# Planning Services Sign Permit Review Form

Date of Submittal	Application Number	Applicant	Landowner
11/16/2023	SIGN2311-0002	Reese Construction LLC	Reese Construction LLC

Contact Person	Clint Reese	Contact Number	919-427-4685
Sign Location	Intersection of Deer Trail Ln. and Cotton Rd.	PIN Number	0643-17-8644.000

**PLOT PLAN**  
 FOR

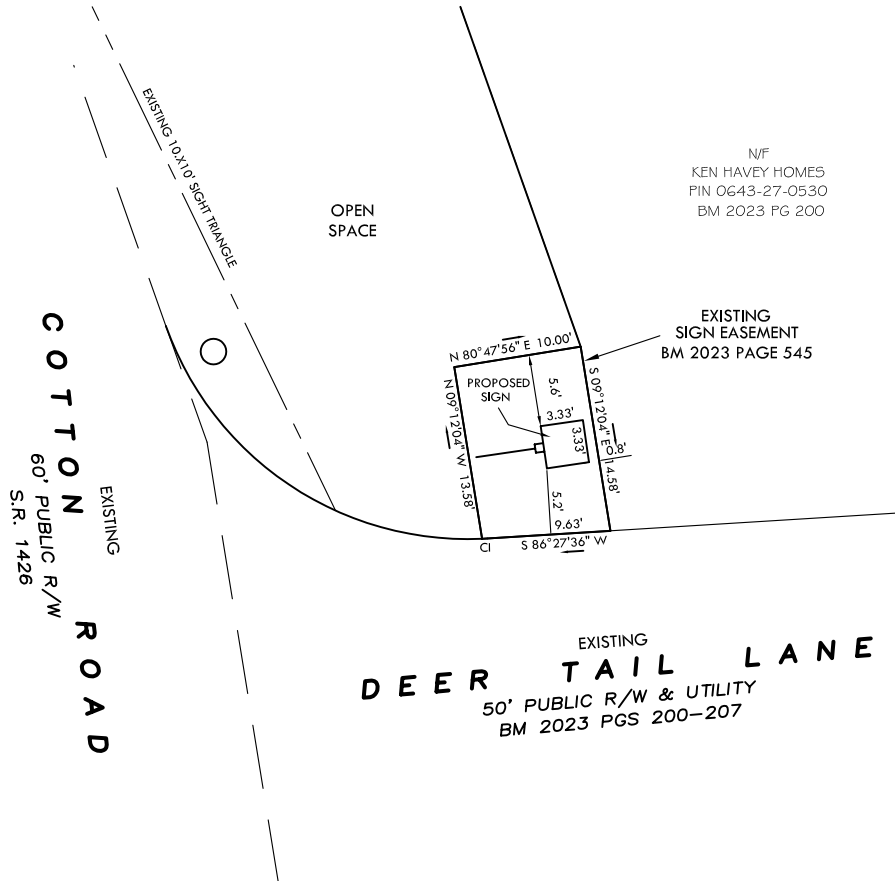
Comments	<ol style="list-style-type: none"> <li>1. The width of the sign is not provided in the attached sign rendering. Please include the total width of the sign, measuring from the beginning of the column to the end of the sign face.</li> <li>2. The minimum 20' setback from Deer Trail Lane is not met, and the setback from Cotton Road has not been provided. The required setback from Cotton Road is 20'.</li> <li>3. According to Map 2023-200, the sign easement is shown on the S. side of the intersection of Deer Trail Ln. and Cotton Rd.</li> </ol>
----------	---
